Please could you upload this email trail and the attached letter onto Ocella for outline planning application A/99/17/OUT -- Land South of Water Lane, Angmering.

Please quote our ref: L-19495-2.4.2-17-C135-KN

**LAND SOUTH OF WATER LANE, ANGMERING
SURFACE WATER DRAINAGE - DRAINAGE OFFICER RESPONSE**

Illustrative Masterplan
Produced by Pro Vision, NTS.

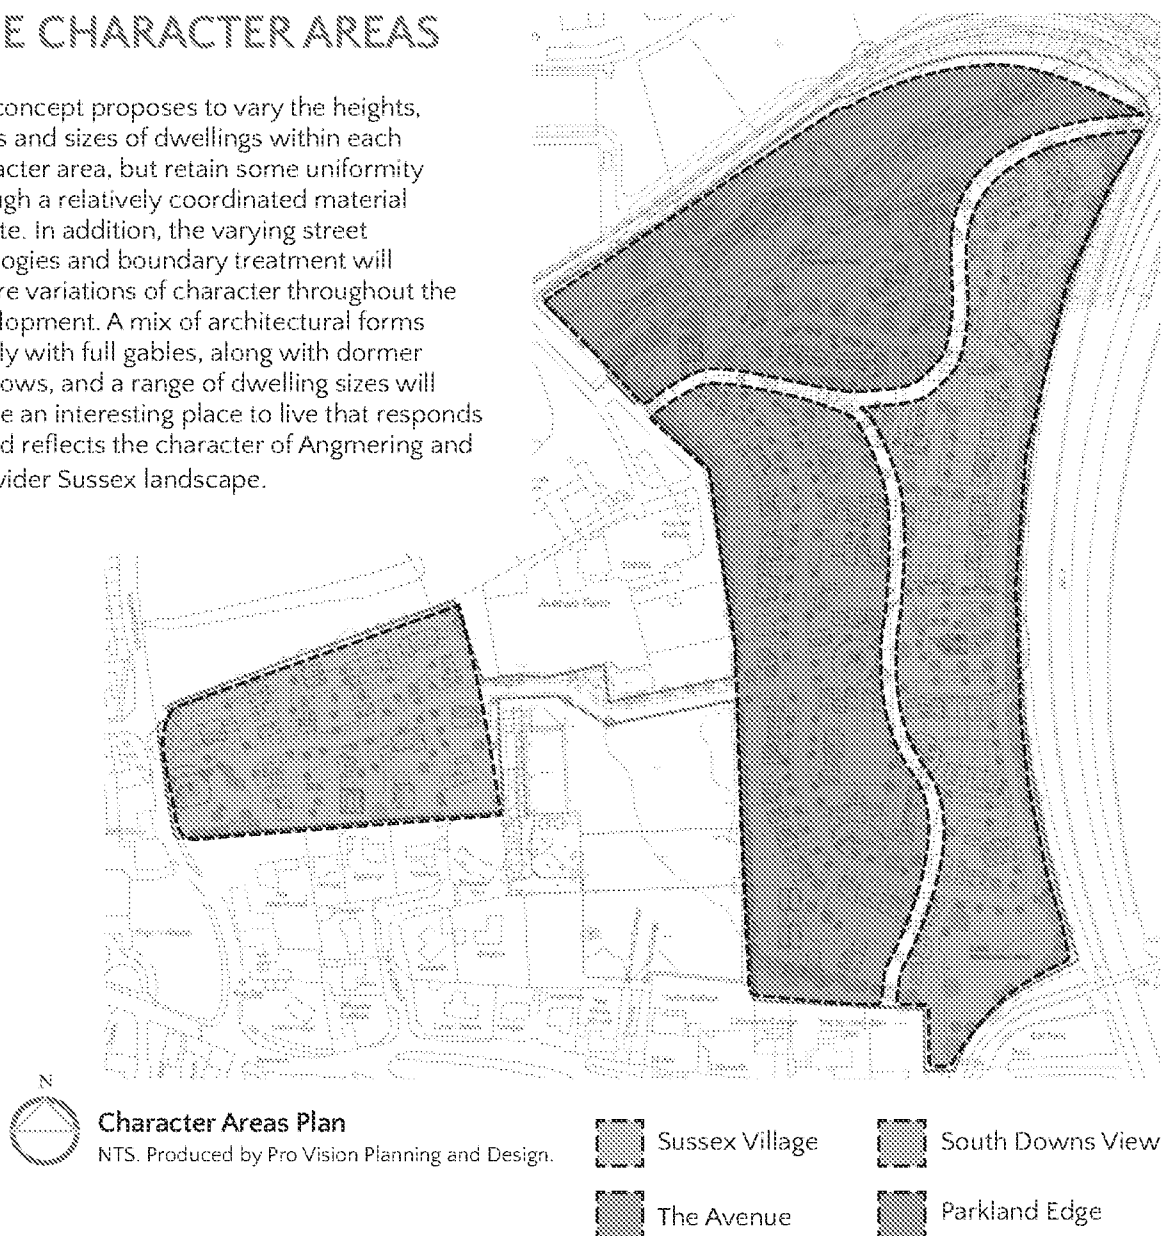
I have no issues with the proposal of splitting one pond into two, provided they can demonstrate that any flood flow exceedance routes do not affect existing properties. Also, access for maintenance of the ponds will need to be secured around their perimeters. This will need to comprise a min. 3m wide strip and this is not currently being achieved on the north sides of the ponds.

At the detailed design stage when there is more certainty about the final layout and plot finished levels, Merebrook will adjust site levels to prevent any overland flows off site, likewise the final attenuation basin designs will incorporate a 3 m wide maintenance strip. It is not envisaged that incorporating the maintenance strip in the detailed design of the attenuation basins will be problematic. The maintenance strip will be provided with due regard to landscaping requirements. For the avoidance of doubt, the outline development proposals will not adversely affect off-site areas as a result of overland flow. Unlike the site in its current form, the site will incorporate positive drainage which will capture runoff from the proposed hard areas and prevent its disposal by uncontrolled watershed.
